Comment for planning application 23/01080/OUT

Application Number	<input type="text" value="23/01080/OUT"/>
Location	<input type="text" value="Land North Of Bicester Avenue Garden Centre Oxford Road Bicester"/>
Proposal	<input type="text" value="Variation of Condition 4 (approved plans and documents), Condition 30 (highway design) and Condition 34 (employment floor space limit) of 17/02534/OUT relating to the erection of a business park of up to 60,000 sq.m (GEA) of flexible Class B1(a) office / Class B1(b) research & development floorspace (now under Use Class E); associated vehicle parking, landscaping, highways, infrastructure and earthworks (Original Application accompanied by an Environmental Statement)"/>
Case Officer	<input type="text" value="Tom Webster"/>
Organisation Name	<input type="text" value=""/>
Name	<input type="text" value="Mark Chivers"/>
Address	<input type="text" value="15 Chelmscote Row,Wardington,Banbury,OX17 1SS"/>
Type of Comment	<input type="text" value="Objection"/>

OXFORD ROAD / MIDDLETON STONEY MINI ROUNDABOUT MITIGATION MEASURES

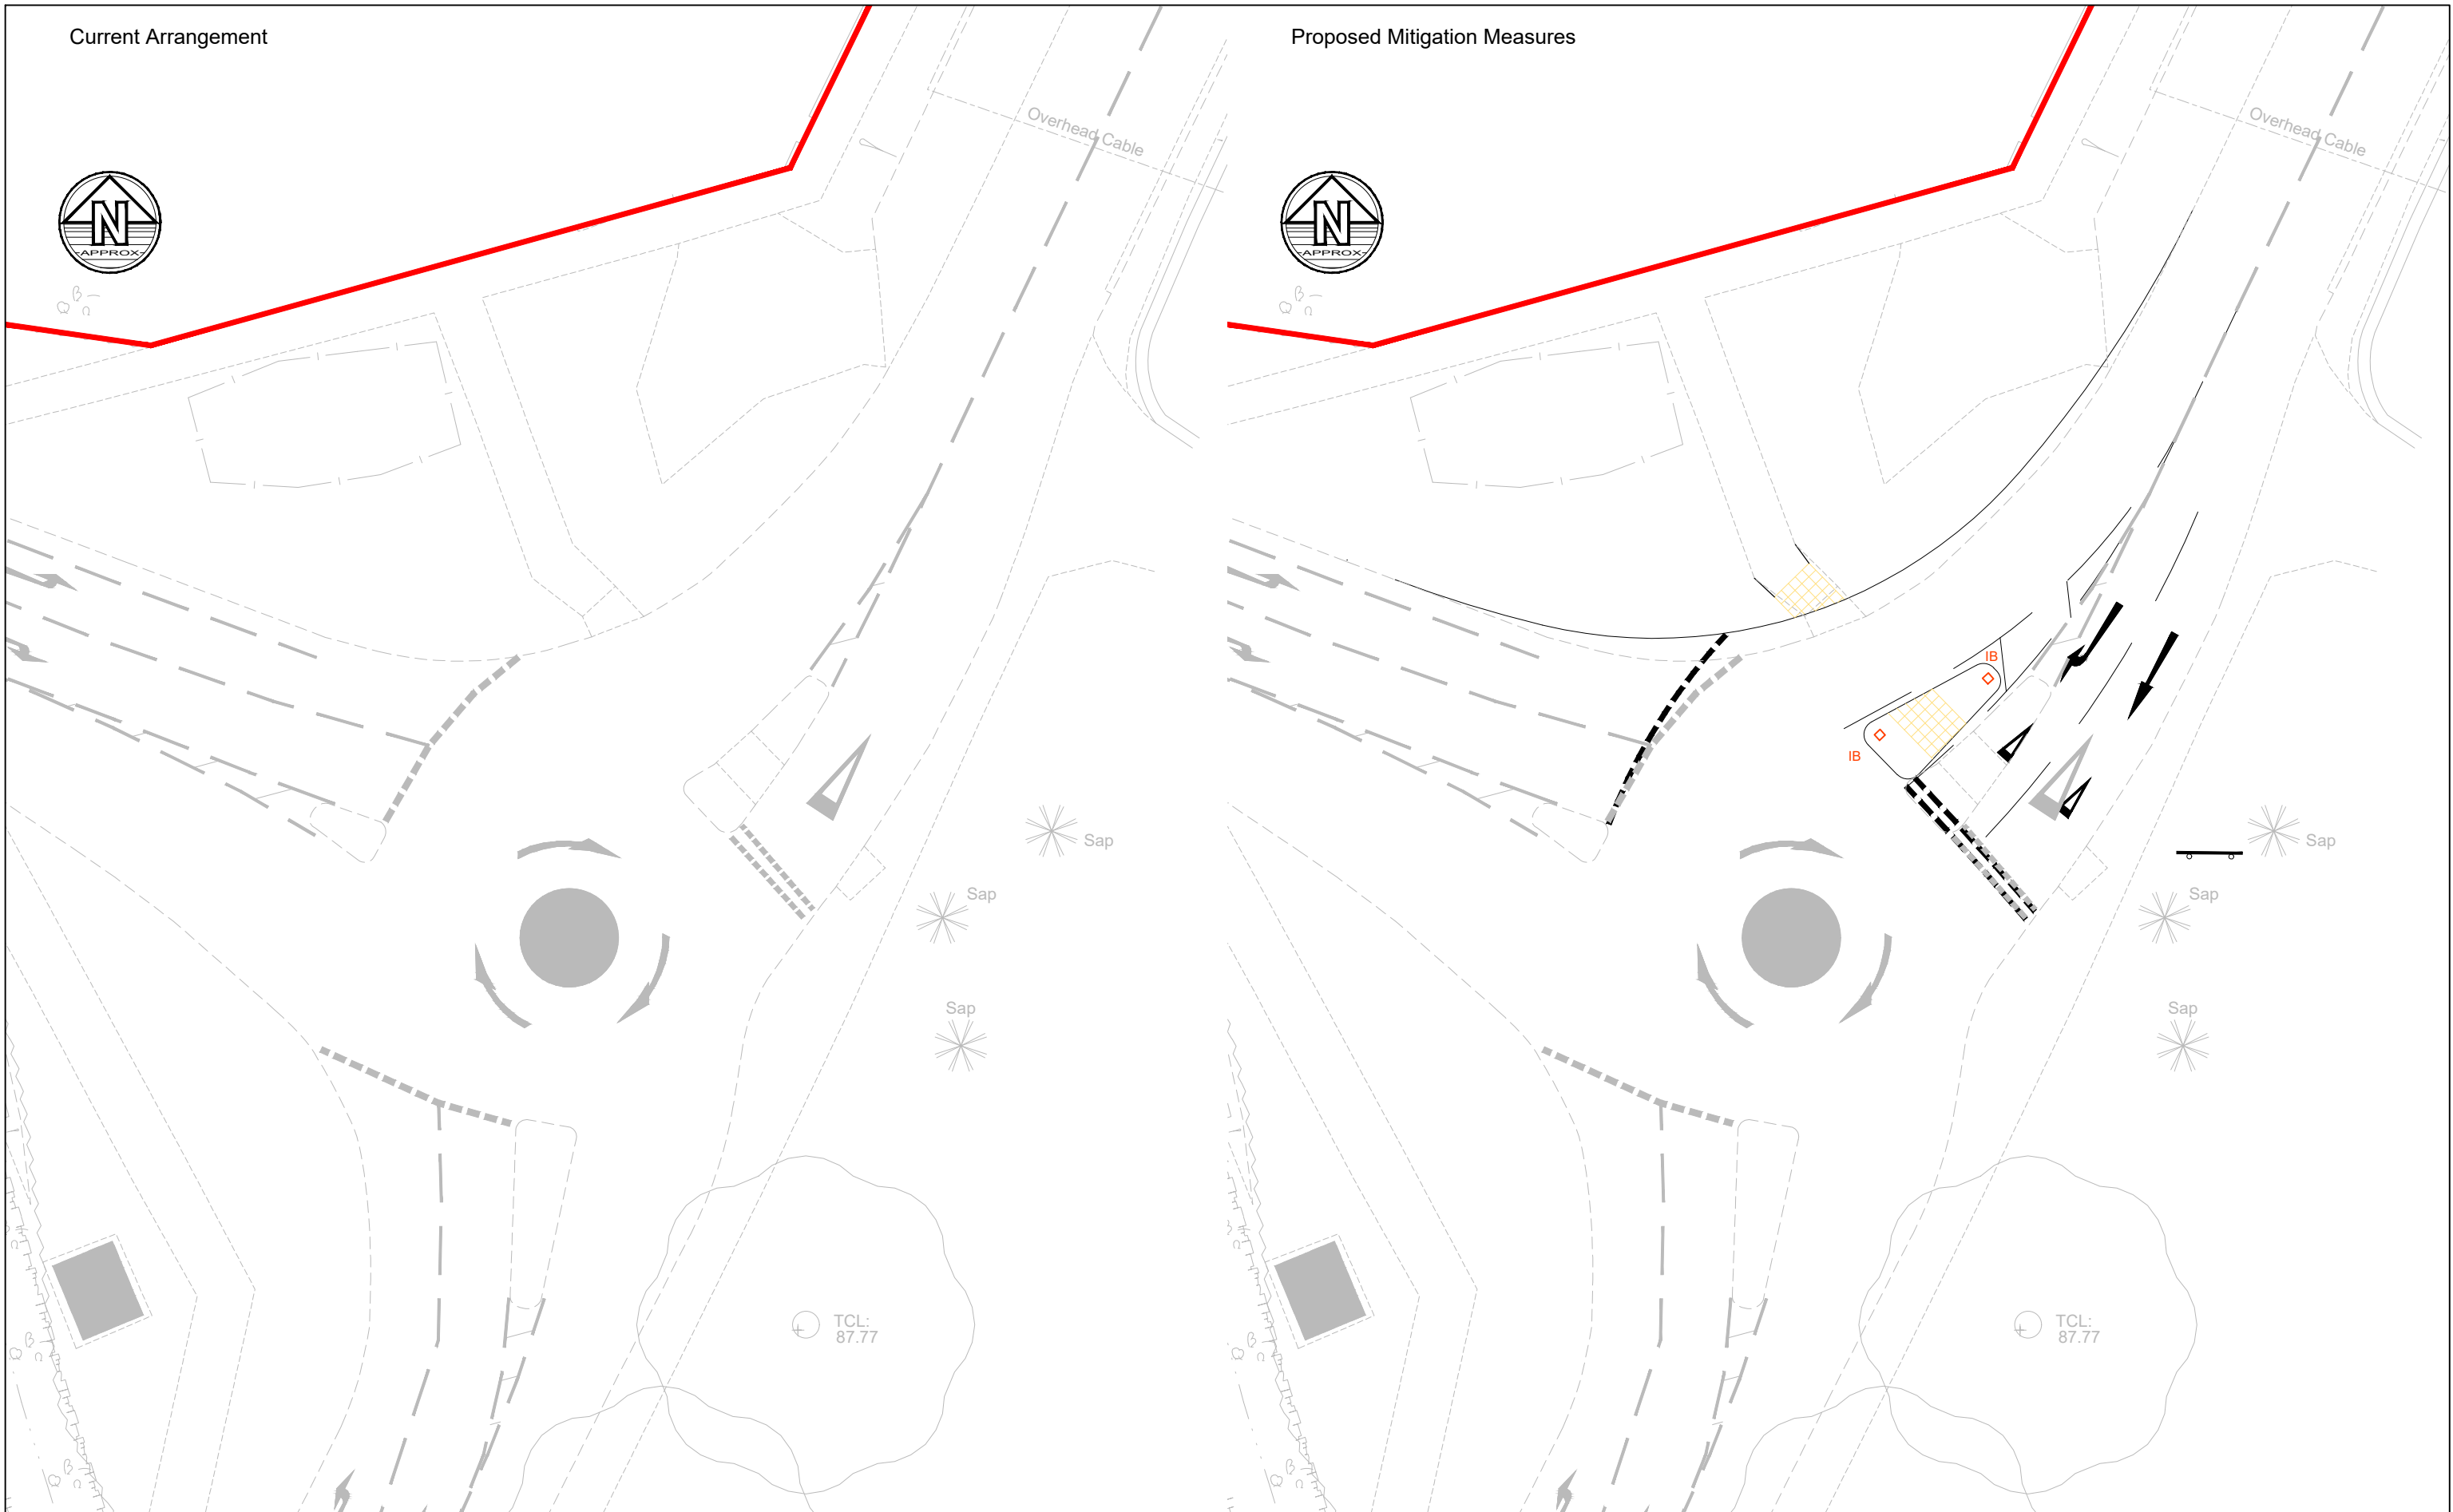
Type	<input type="text" value="neighbour"/>
Comments	<input type="text" value="Current proposed design would make journeys by foot or bike, which CDC is meant to be encouraging, more difficult. Especially for people with disabilities including on mobility scooters as I do not believe that the pedestrian refuges will be big enough. Traffic flow and control seems more than sufficient at this time and I do not see the need for these works, in fact the only impact from the proposed building works would be to create delays. I ask that this application is rejected and a new plan requested."/>
Received Date	<input type="text" value="01/11/2023 17:05:39"/>
Attachments
